APPROVED  
Limited building only review  
Permit holder responsible for full compliance with the code

Elevations Plan

The Gavin II

First Floor Electrical
Plan

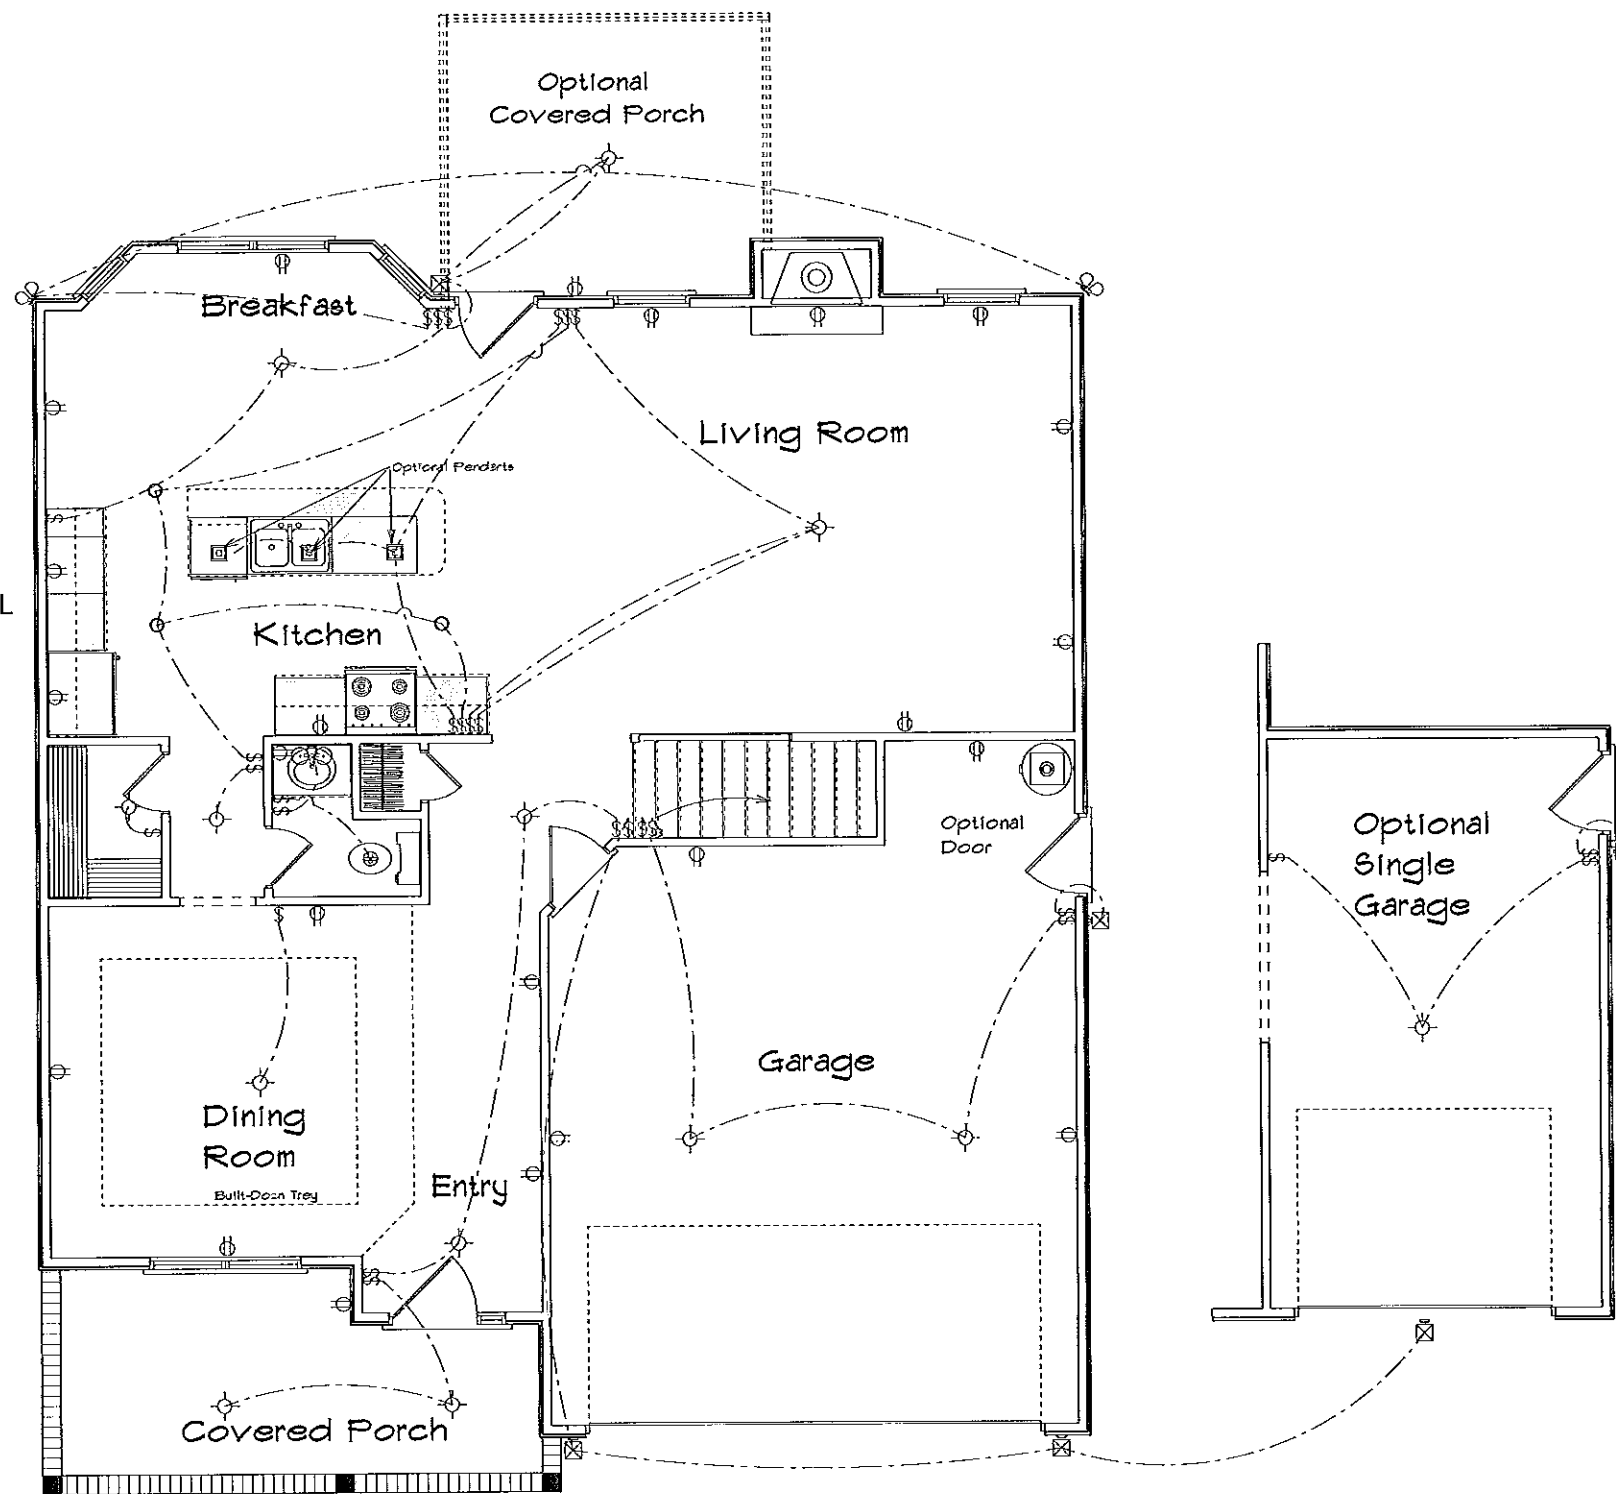
WIRE TO ISLAND NEEDS  
TO BE 84" FROM RANGE WALL
